# SWMP Plan\_V1.pdf Markup Summary

**Subject:** Engineer  
**Page Label:** CE1.9  
**Author:** dotprete  
**Date:** 8/6/2022 3:52:33 PM  
**Status:**  
**Color:** ■  
**Layer:**  
**Space:**

CE1.9

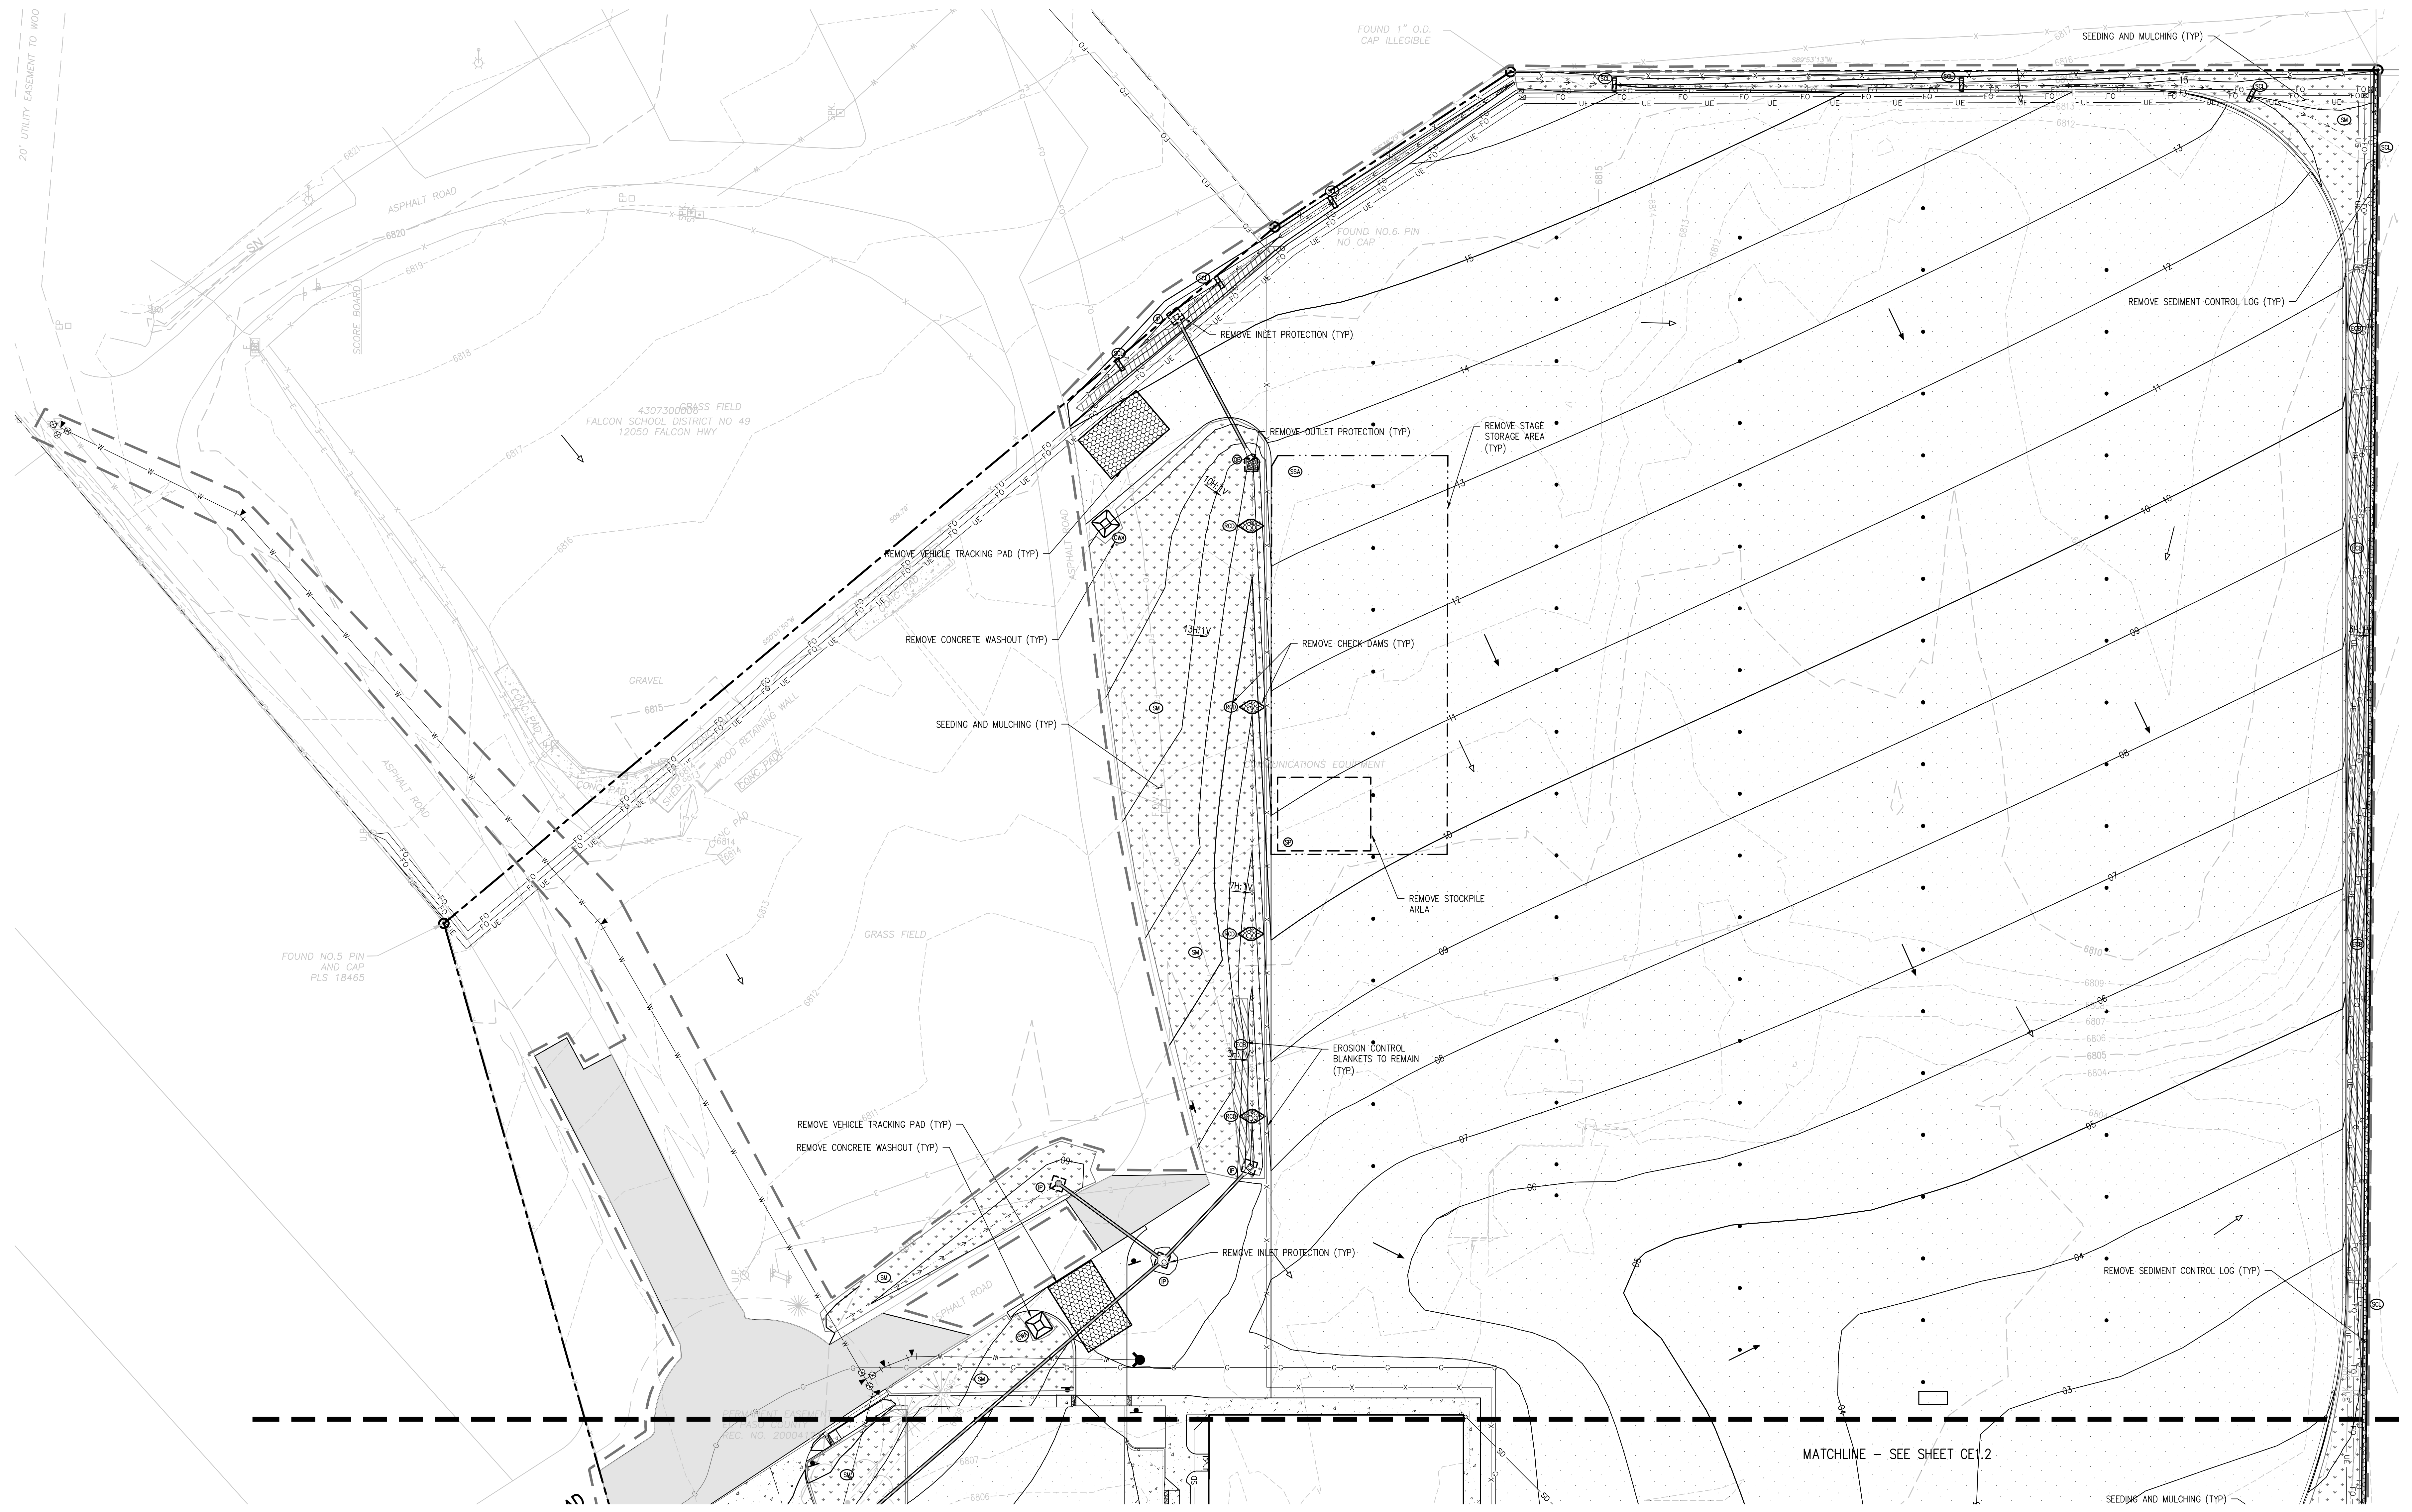
Item 9. Please include method for determining ground cover (i.e., visual, aerial inspection)

Item 10. Potential pollution sources are associated with proposed construction

Item 8. Include soil erosion potential and impacts on discharge

Item 8. Include soil erosion potential and impacts on discharge

70% of pre-disturbed levels

(i.e. VTC)

installed prior to the start of construction

We have been seeing a lot of blow outs when using straw bales in ditches after a large rain event. Consider using straw wattles (or rock checks) in lieu of straw bales.

How will runoff be contained and what type of filter? I dont think this level of treatment is necessary with your typical construction materials and equipment.

Item 11. Please include a spill response plan and procedures

every 14 days and after each rain event or snowmelt event that causes surface erosion

and County

Item 22. Include a short discussion about the proposed structural and nonstructural water quality control measures.

Item 26. Add a note stating that this project does not rely on control measures owned or operated by another entity.

Item 12. Note that this project does not anticipate utilizing batch plants in the SWMP text

Item 13. Discuss inspection procedure for checking waste disposal bins for leaks and overflowing capacity. And discuss frequency that they will be emptied (or at what level of capacity would trigger the need to be emptied)

Item 16. Include a description of all stream crossings located within the project area or statement that no streams cross the project area

Item 21. Add text stating that the SWMP should be viewed as a "living document" that is continuously being reviewed and modified as a part of the overall process of evaluating and managing SW quality issues at the site. The QSM shall amend the SWMP when there is a change in design, construction, O&M of the site which would require the implementation of new or revised BMPs or if the SWMP proves to be ineffective in achieving the general objectives of controlling pollutants in SW discharges associated with construction activity or when BMPs are no longer necessary and are removed.

The SWMP should be a stand alone document, in accordance with ECM Appendix I.4.1  
Once approved, it should be printed out and kept onsite for the duration of the construction. During construction it should be marked up to reflect changes in the field.

During each County Stormwater inspection, our inspectors will review the SWMP and note any deficiencies. It would be very helpful to our inspectors if you could reformat the SWMP so that it is on 8.5 x 11 paper so that it is easily legible. The SWMP will also require a Cover Sheet, Table of Contents, and Appendices. See attached SWMP example with all necessary appendices

discuss the temporary sediment basin
